**COMMENT ON PLANNING APPLICATION NUMBER: 6/2019/1688/HOUSE
ADDRESS: 69 LAVENDER CLOSE, HATFIELD, AL10 9FW**

2626 - 2

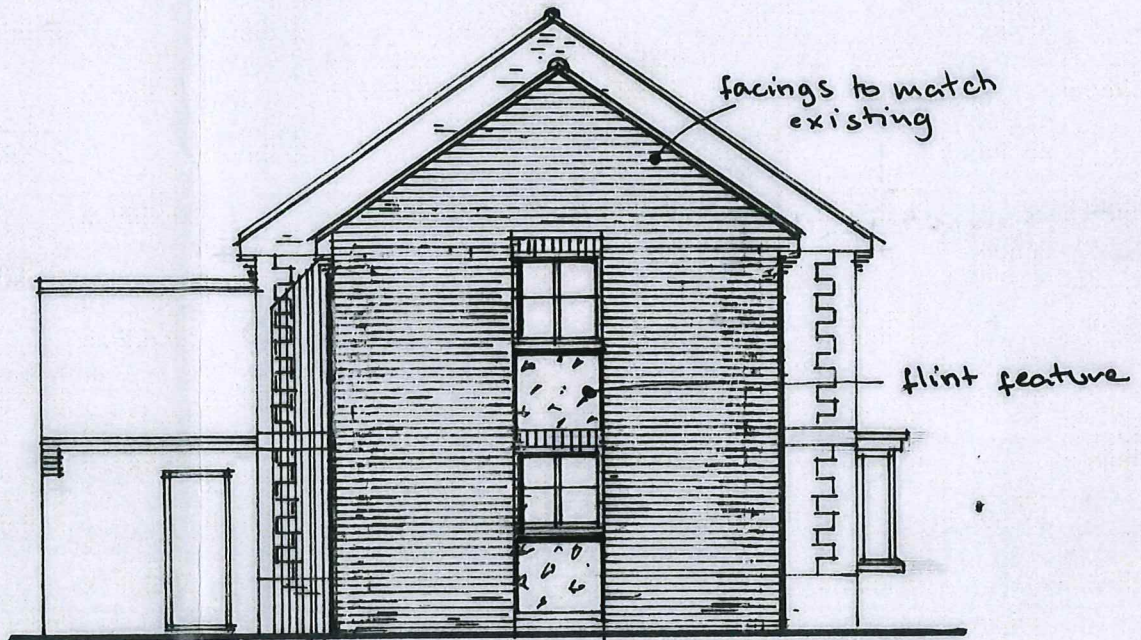
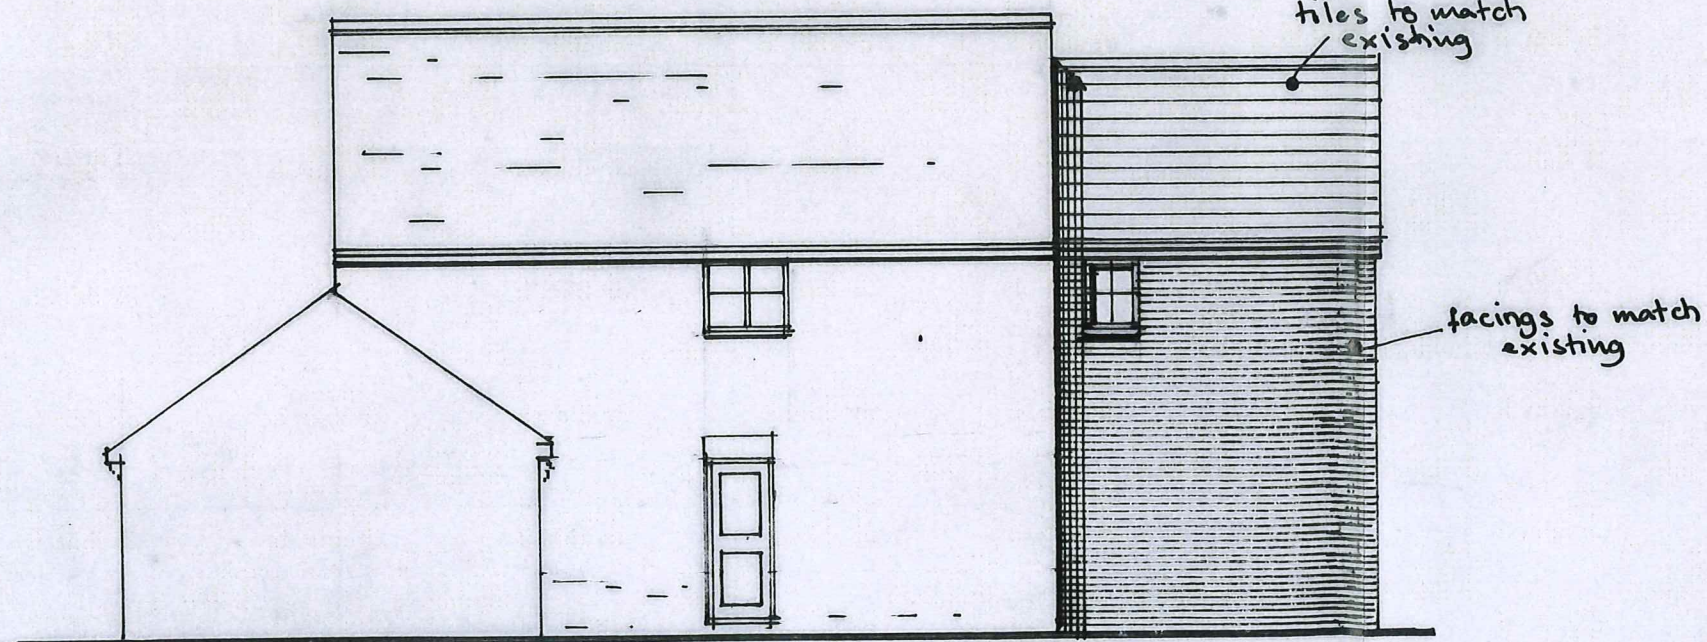
1. The length of the extension of circa 4m brings it closer to our property and with the windows being proposed will further overlook our property and we have serious concerns in regards to privacy to our side garden, kitchen and bedroom. Please note that between 30 Lavender Close and 33 Cornflower Way, where the distance between the two properties will be similar to our property and that being proposed, there is an absence of windows where I assume maintaining privacy was the key reason.

2. The material being proposed does not match the existing in terms of proportion of flint and brickwork. Currently the side elevation has an extensive flint finish which would be replaced with primarily less attractive brick wall. The proposed flint between the windows is significantly less than existing in both the side and front elevations and appears a token effort to match. Also, the proposed material is significantly different and inconsistent to that of the main house.

3. The proposed extension in combination with the main house in our view appears overbearing in terms of its scale and mass even though there is a slight setback to the front, side and roof level and is not in keeping with the immediate surrounding area and in Hatfield Village in general.
